**SGA** Design Group

RE: Walmart #5430.248 – 3500 Coors  
Project #PR-2019-002231  
Administrative Amendment Request  
Transportation Development Comments – RESPONSE

DRAWN DJS
CHECKED BOA
DATE 05/05/2021
SCALE VARIES
JOB No. SGAD5491
SHEET SSM-1

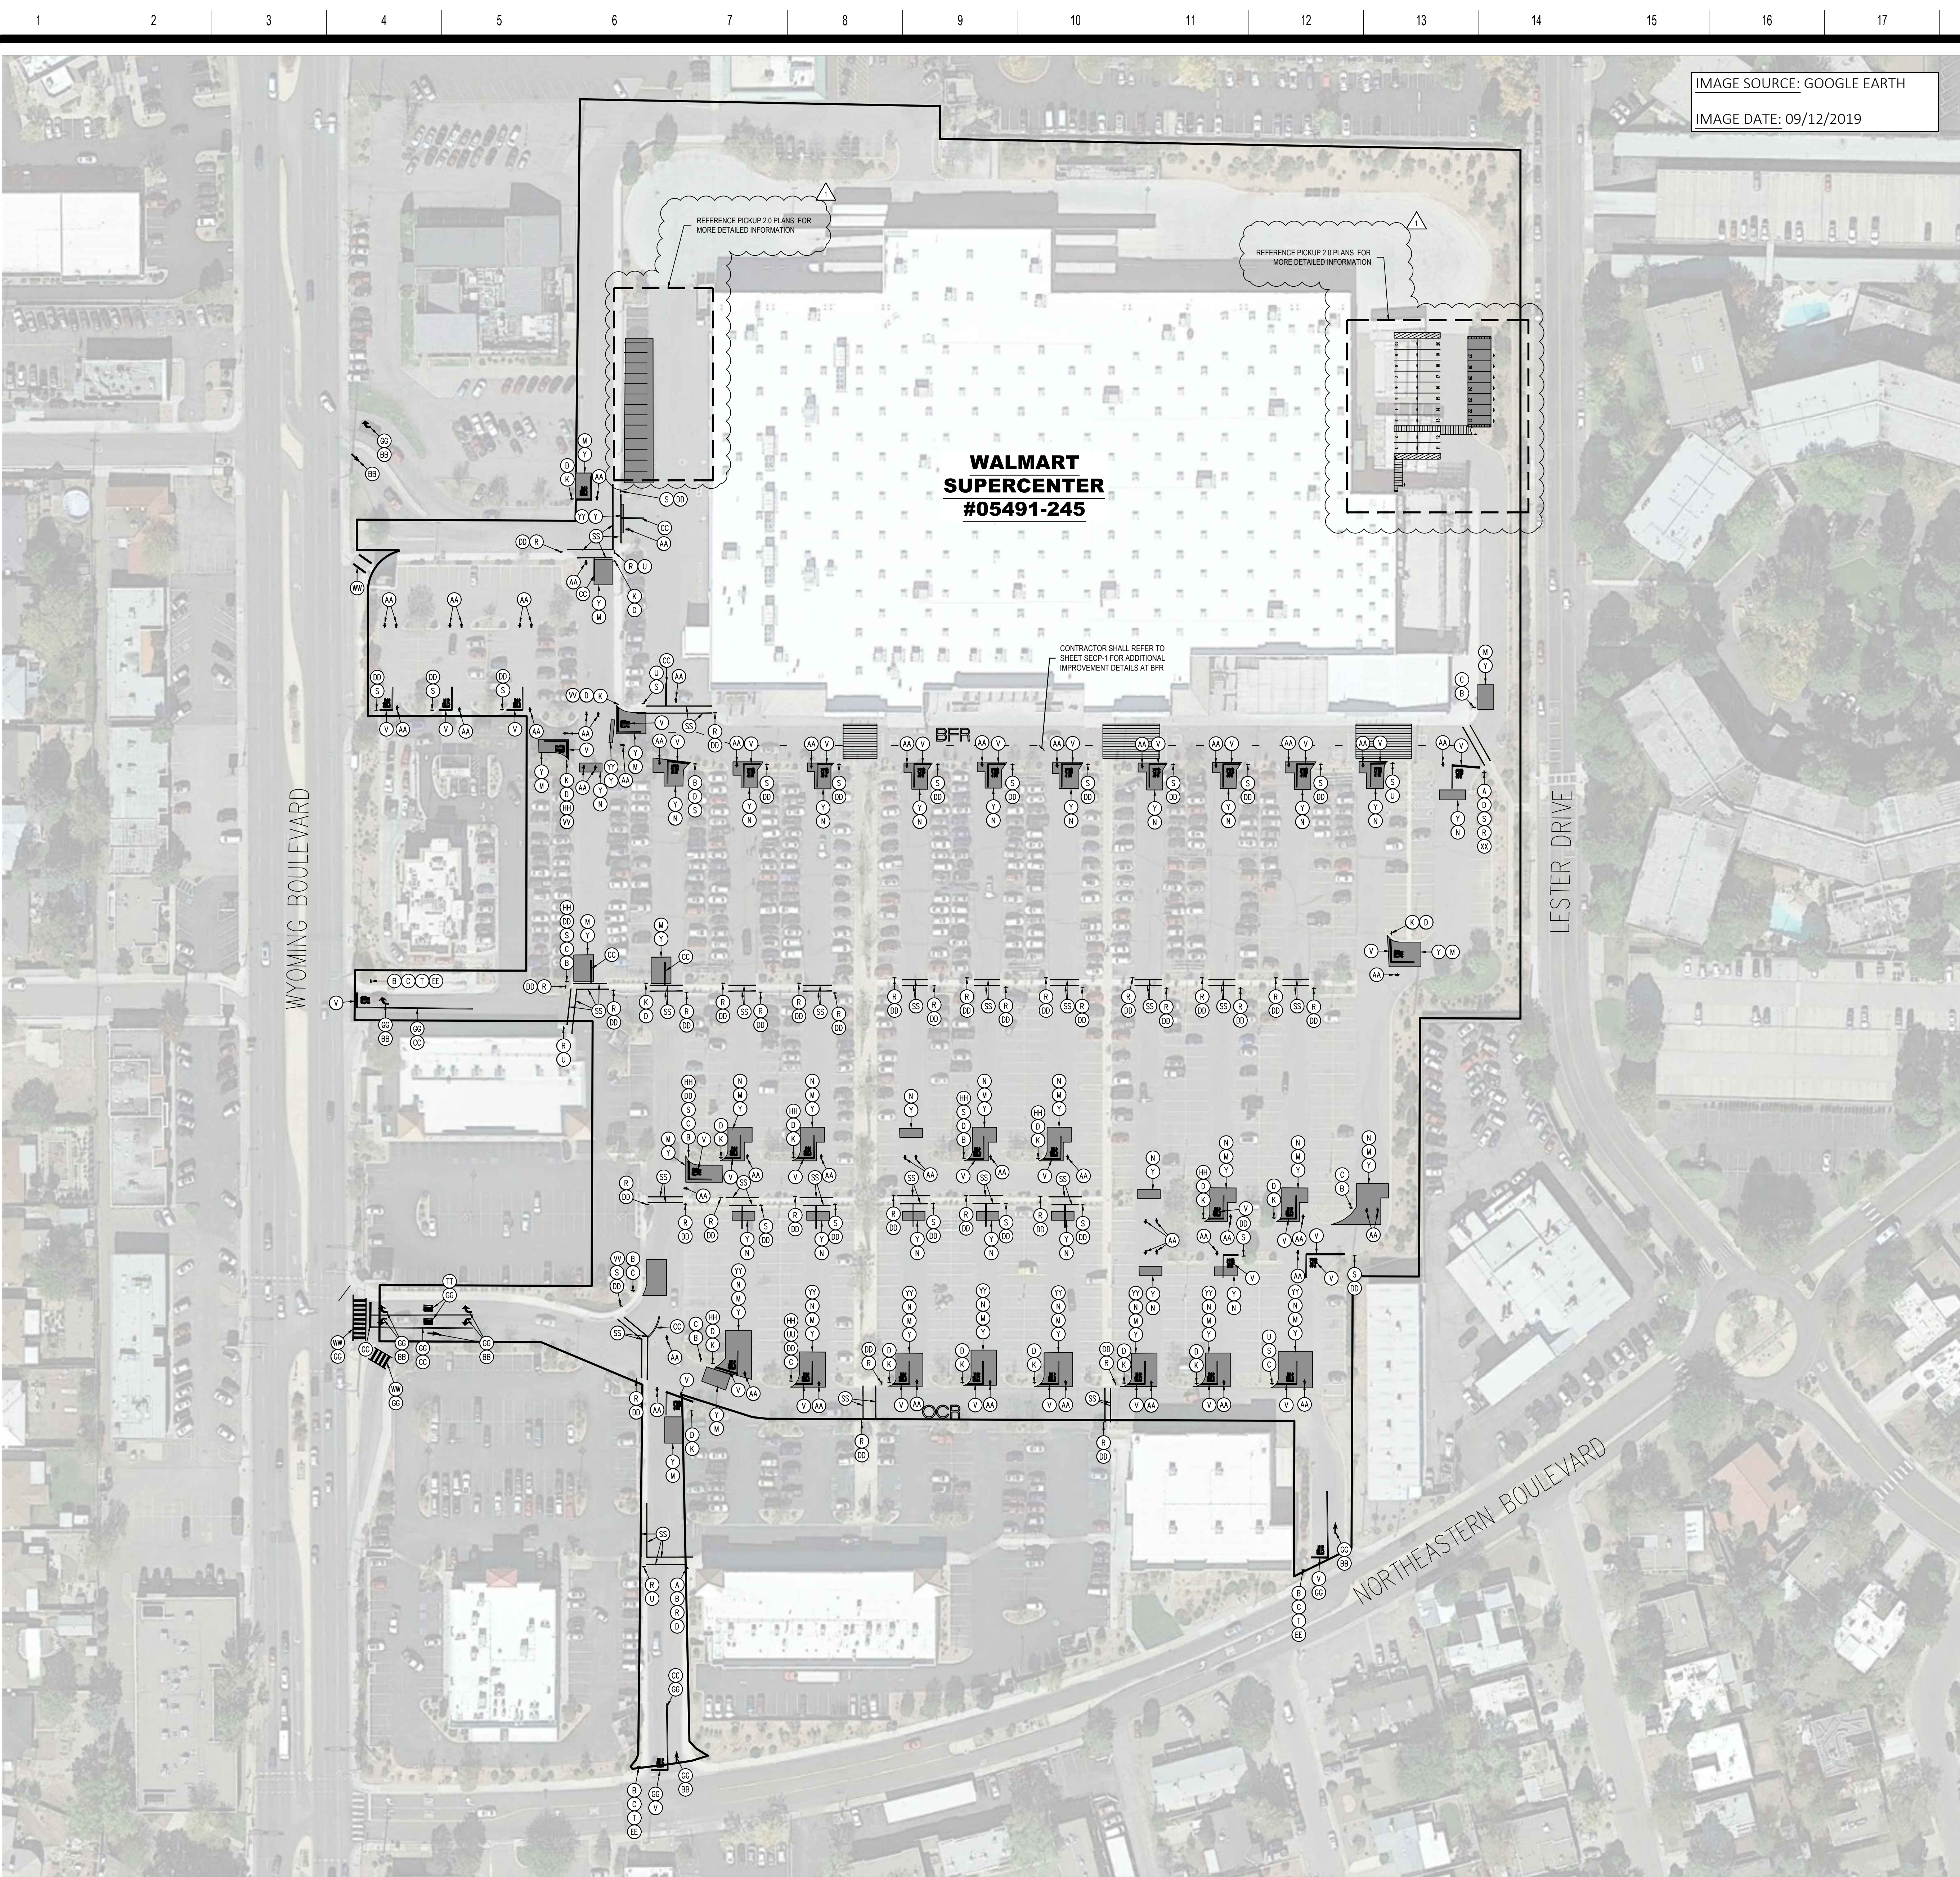
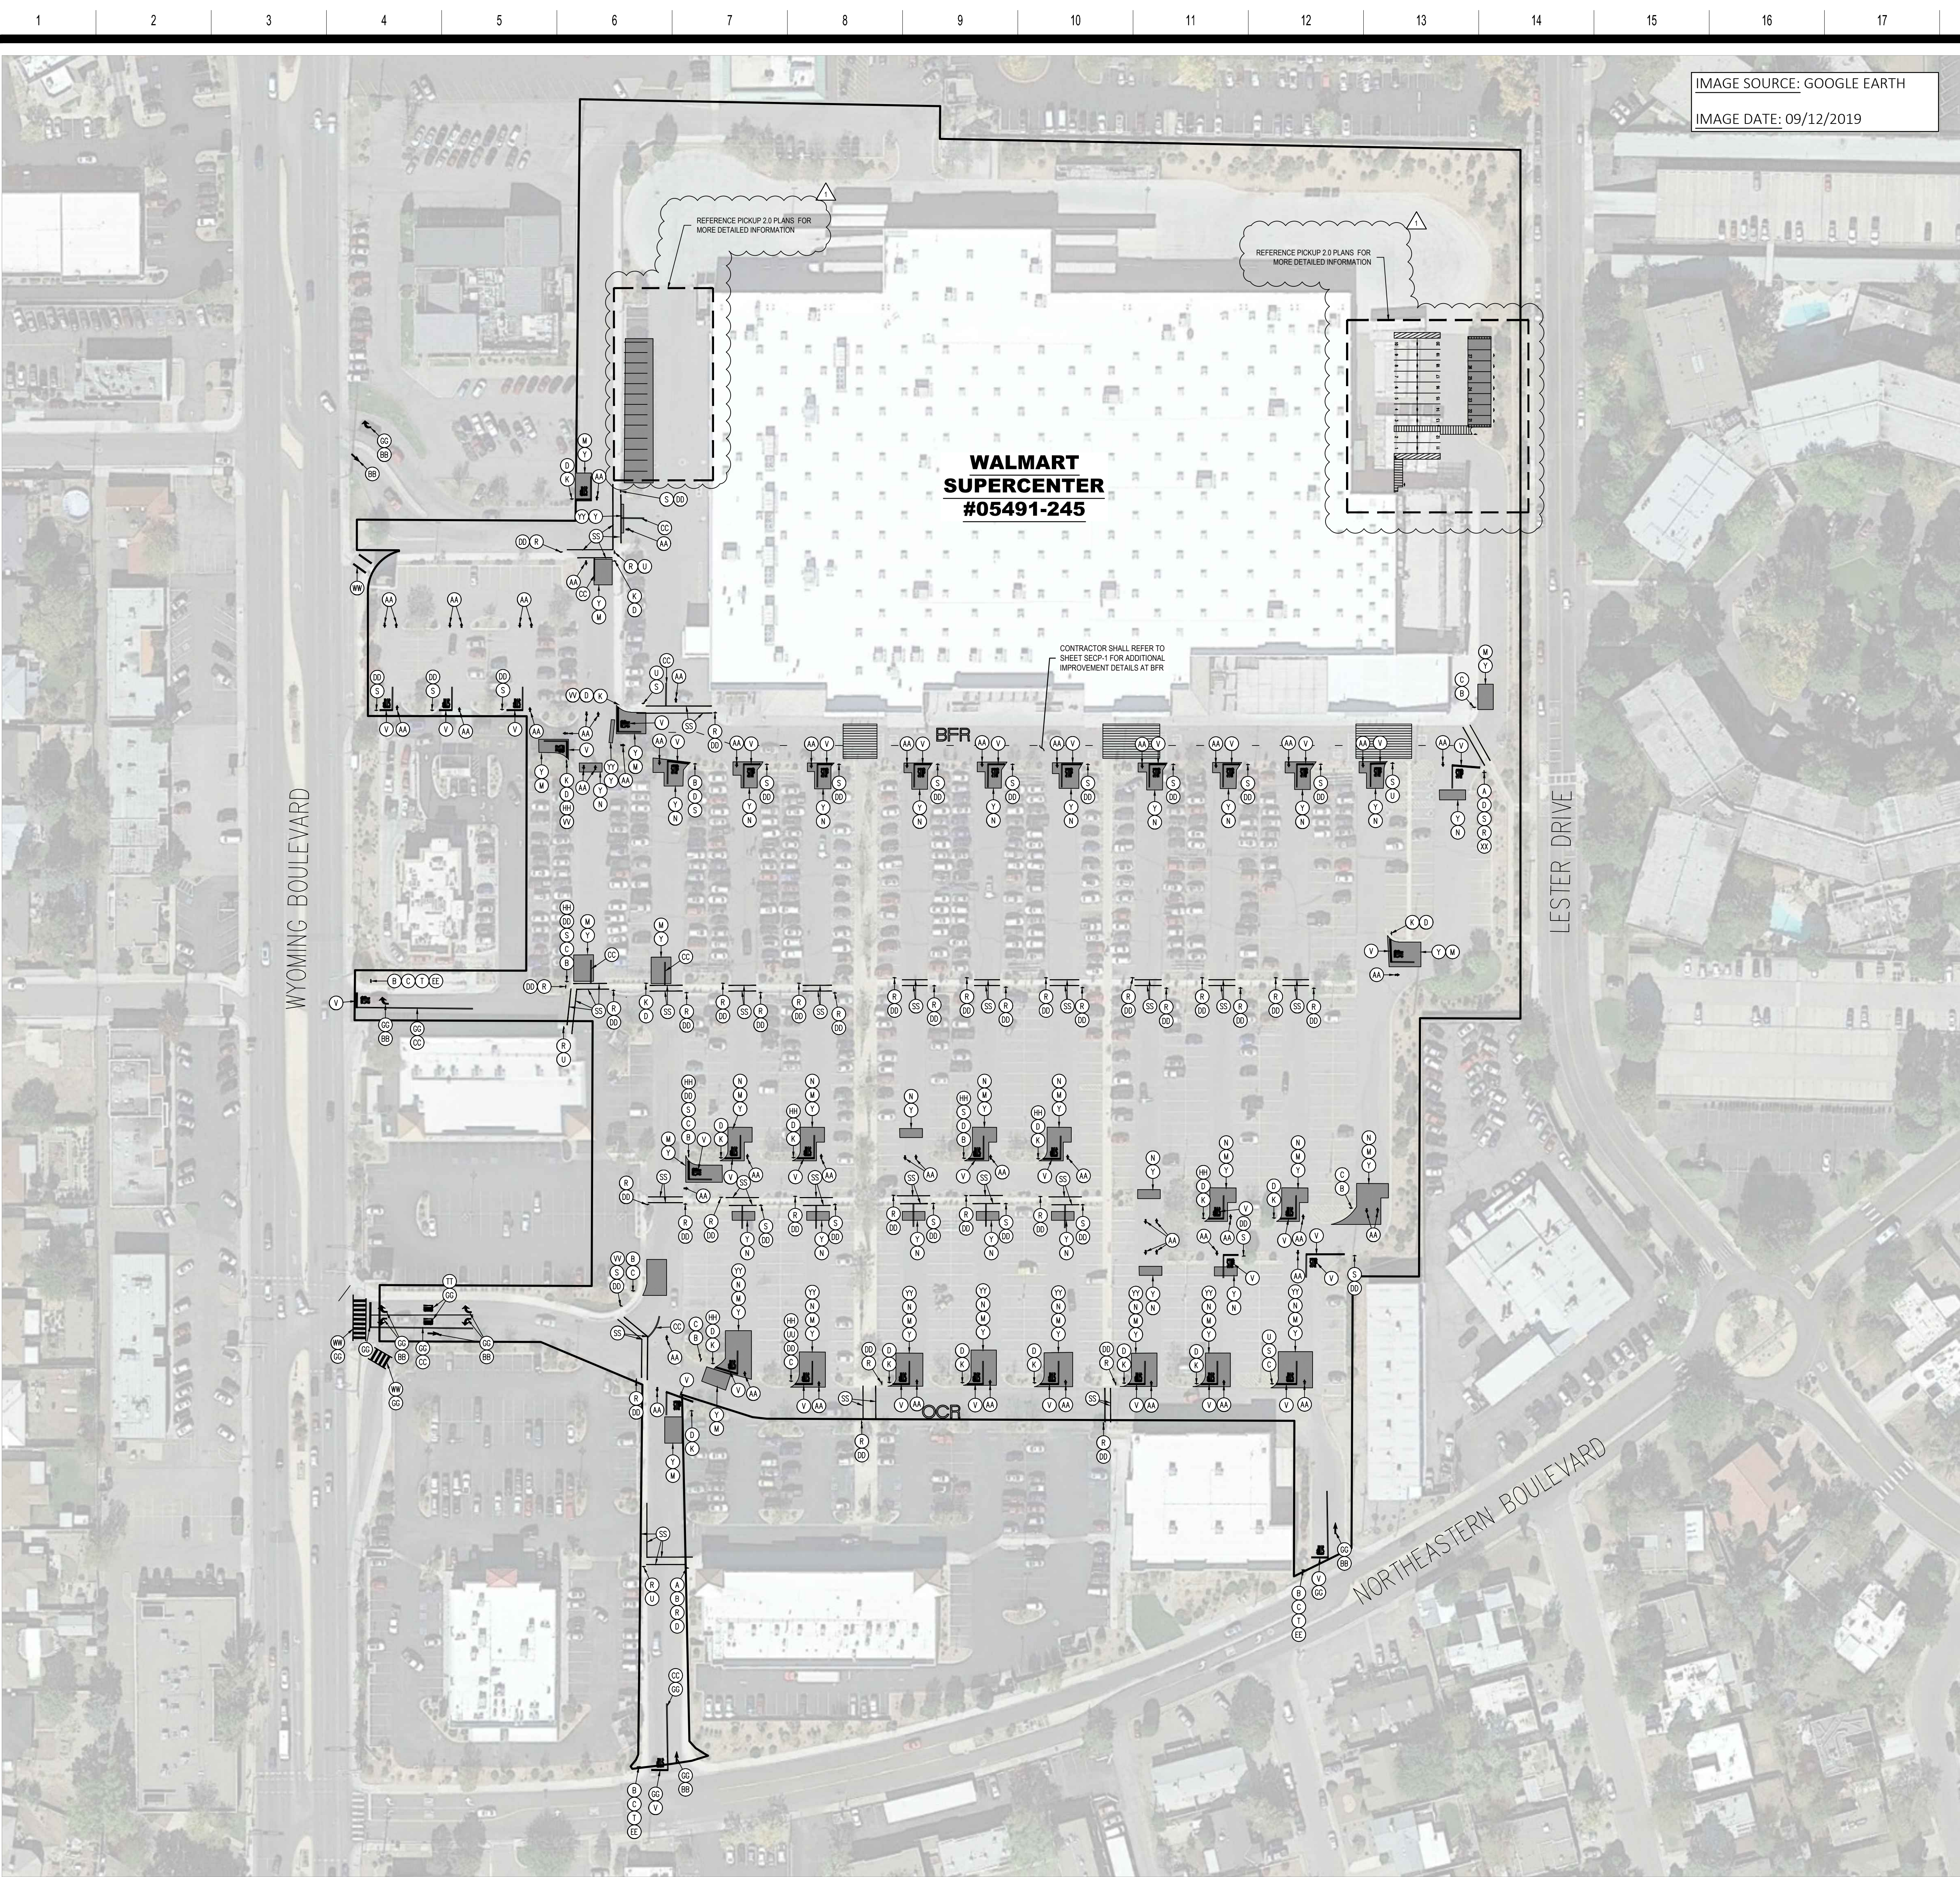
Comment 1: Place signage from Loris Drive to direct drivers to pick-up area.

Comment 2: Update parking calculations based on the site plan changes provided.

Comment 3: For Keyed Note 10 on the crosswalk at the north end, it should line up with the concrete area or landscape island rather than being directed toward the middle of a driving aisle.

Comment 4: Clarify if the 40-foot-long parking spaces were meant to be set up that way for the new pick-up spaces, and dimension the driving aisle to the west of these spaces. If these were meant to be for longer vehicles, demonstrate that they are able to maneuver in and out of the parking spaces.

**Response 1: Acknowledged – Please see Civil documents attached.**

**Response 2: Acknowledged – Please see Civil documents attached.**

**Response 3: Acknowledged – Please see Civil documents attached.**

**Response 4: The 40-foot-long parking spaces are for stacking of vehicles to pull under the drive through canopy in use.**
